**From:** Charlotte Watkins  
**Sent:** 27 January 2023 09:23  
**To:** Chris Wentworth  
**Subject:** 22/01488/OUT

22/01488/OUT

**Ecology Officer**

FIGURE 6: ILLUSTRATIVE LANDSCAPE STRATEGY

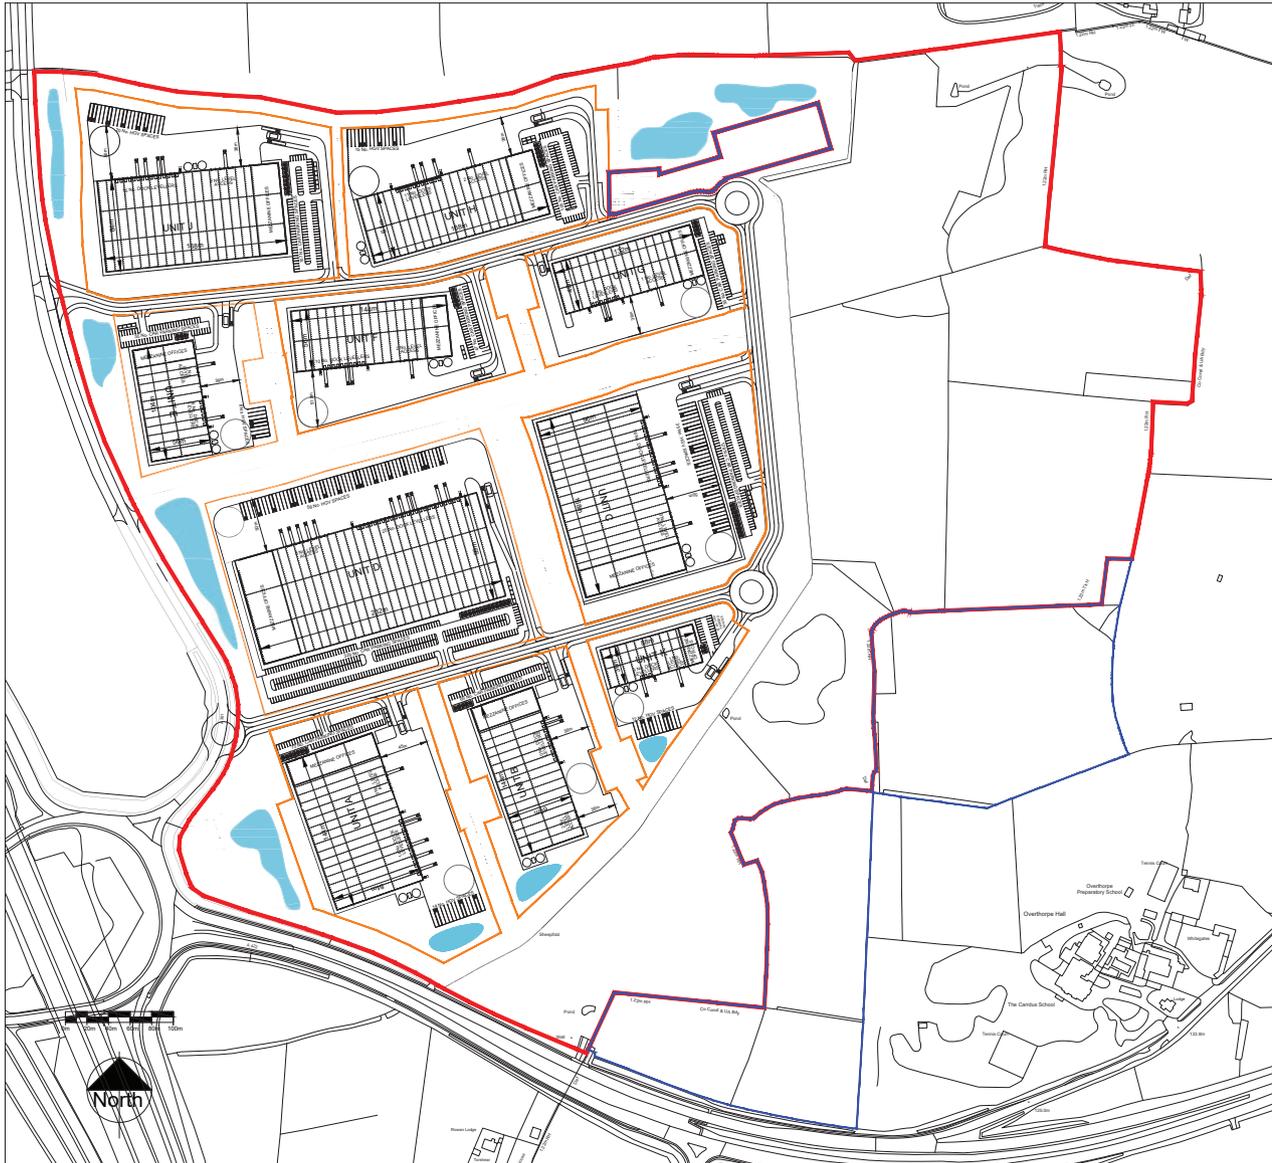
The applicants have submitted a BIA metric. This has been updated with a less ambitious habitat enhancement (now proposing other neutral grassland rather than lowland meadow) which is more realistically achieved (but means the net gain demonstrate is significantly less). I don't think the illustrative landscape masterplan has been updated to reflect this?
